New Epping South Public School - SSD-8873789

Exhibition of State Significant Development Application – Response to Submissions and Amended Proposal

Figure 8 | Stage 3 site layout (Source: Applicant's RtS 2021)

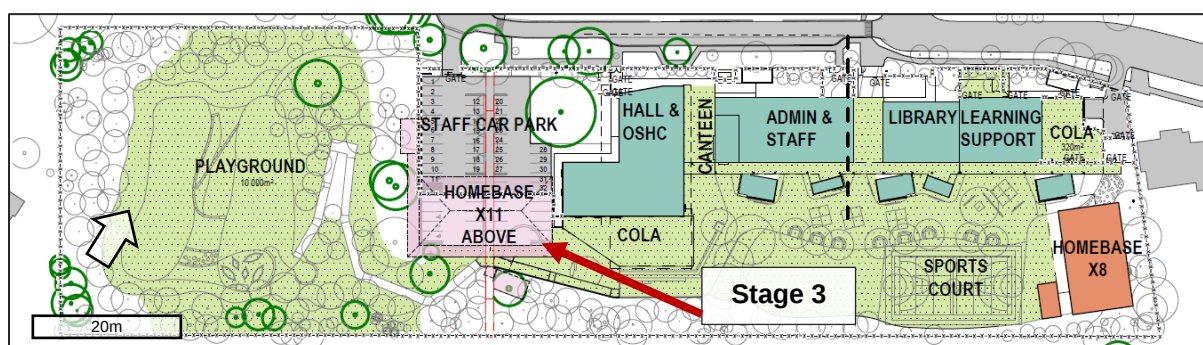
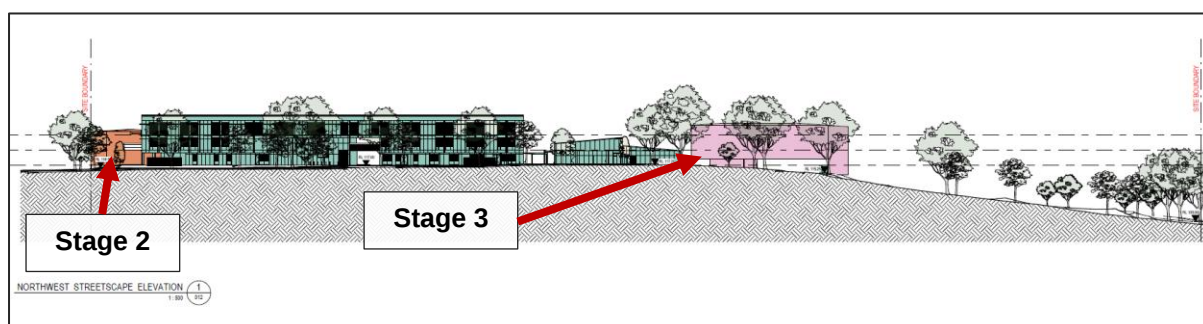
The Trust accepts the logic of moving the Stage 3 building from its original location, to facing Grimes Lane, though this will of course materially affect those residents facing this building.

However, having made this major change, we cannot understand the logic of keeping the staff car parking at street level (with the building over it). Why on earth would there now not be consideration of putting this parking underground? That would then free up two stories (ground and level one) for school space – future proofing the school for additional growth. It does not appear that any feasibility has been done on a different approach to this car parking. What a wasted opportunity.

Figure 27 | DOPU zone (in green) (Source: Applicant's RtS 2021)

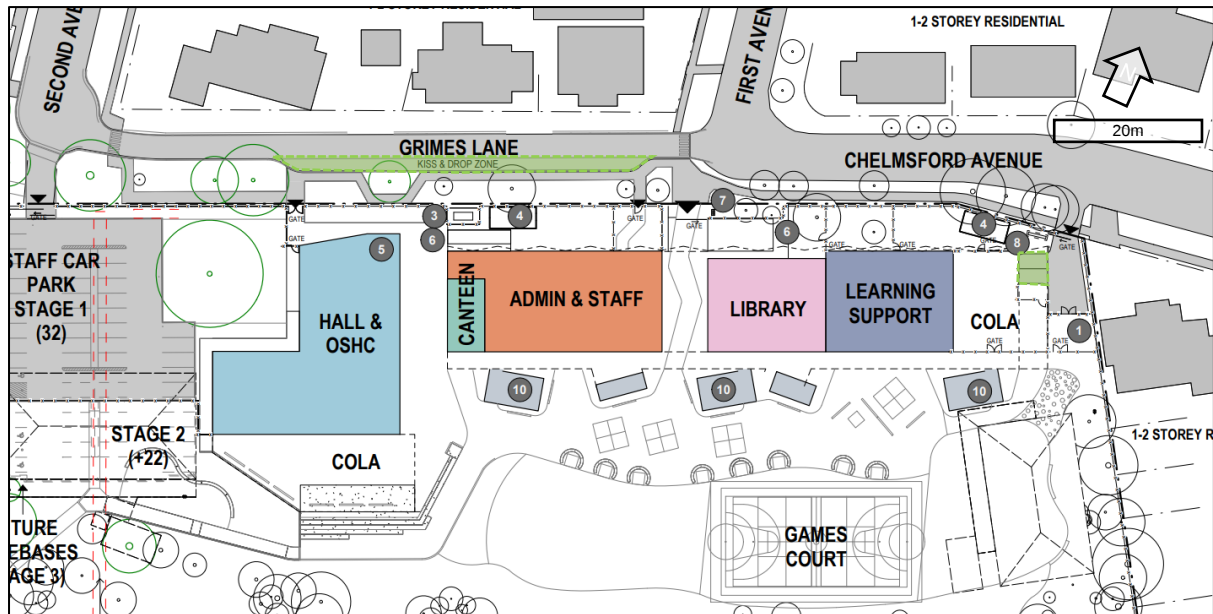
The main report contains a lot of words explaining the methodology of calculating traffic movements along the new one way Grimes Lane at peak times. But it cannot hide the basic fact that the kiss n drop area is insufficient. It will only cater for approx.

60% of the cars that will wish to avail of it. The DA finds it acceptable for the remainder to just spill on to the surrounding streets – bringing with it more noise, traffic and bad parking to affect the life and amenity of residents.

That is not satisfactory.
